Application Reference: 2025/0132

Site Address: 21 Wellhouse Lane, Penistone, Barnsley, S36 8ER

This application seeks full planning permission for a loft conversion with roof lights and render to the dwelling.

Drawing Title **PROPOSED PLANS**

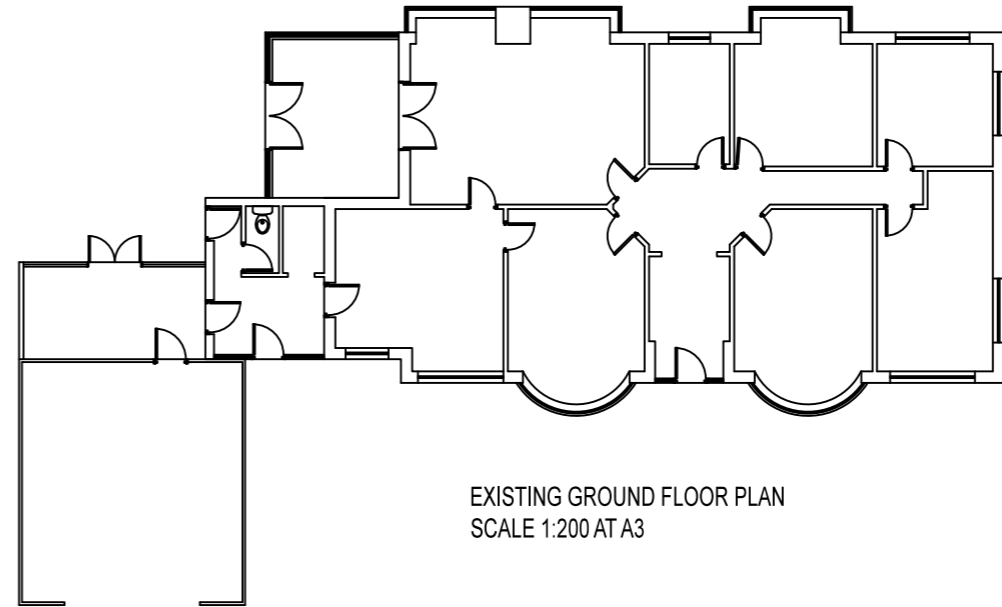
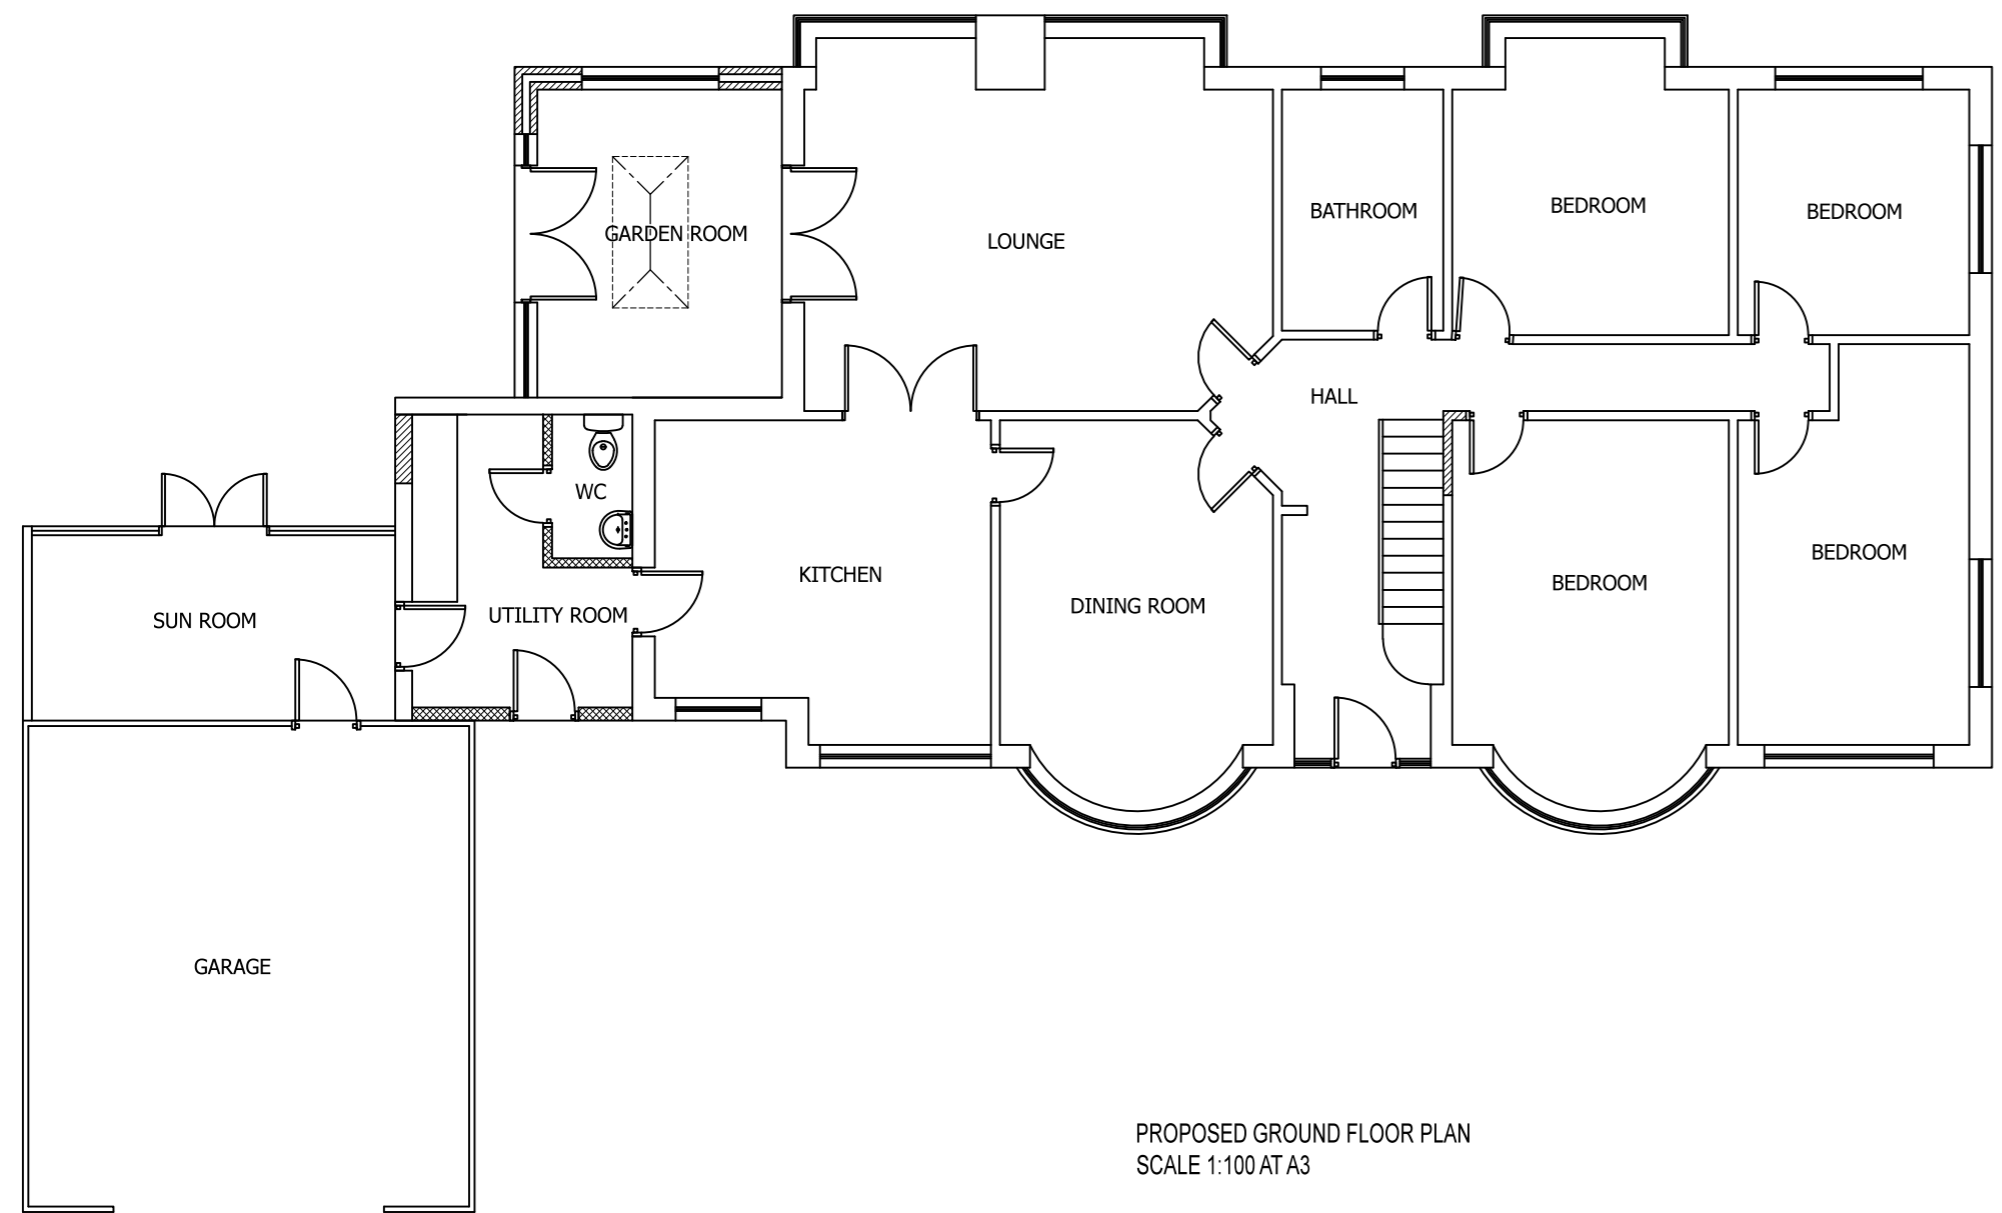
The applicant is seeking the full planning permission for a loft conversion with roof lights and render to the dwelling. The scheme has been amended as the scheme previously included dormers to the front and rear of the property, along with timber cladding to the front of the property. The LPA had been in contact with the applicant over the issues of the timber cladding, render, and dormers that were present on previous plans.

As mentioned at the beginning of this report changes have had to be made to this proposal as the previous design was not in keeping with the design and character of the surrounding area. The LPA made it clear to the applicant that dormers to the front of the property and the wooden cladding were not acceptable. The applicant argued that the property over the road at 26 Wellhouse Lane had wooden cladding, however it was explained to the applicant that this property had its planning application approved before the Council adopted the House extensions and other domestic alterations SPD (2024). As such that application did not have to adhere to the most recent SPD. That property is the only property in the area that has wooden cladding, and it was explained to the applicant that number 26 was the only property in the area which had the cladding and thus does not adhere to the rest of the character of the area.

The applicant previously proposed dormers to the rear of the property. These have been removed as the LPA explained to the applicant that the installation of dormers would cause overlooking issues into the new homes which are being constructed at the rear of the site. The LPA suggested that the applicant also install roof lights to the rear of the property so that the loft conversion would still benefit from light. The applicant agreed to amend the plans; therefore the scheme is acceptable as it would not harm the amenity of any of the

Therefore, the current plans show the removal of the dormers and wooden cladding, and the amount of render has been reduced to be in more keeping with the surrounding character. These issues are discussed in more detail in the rest of the report.
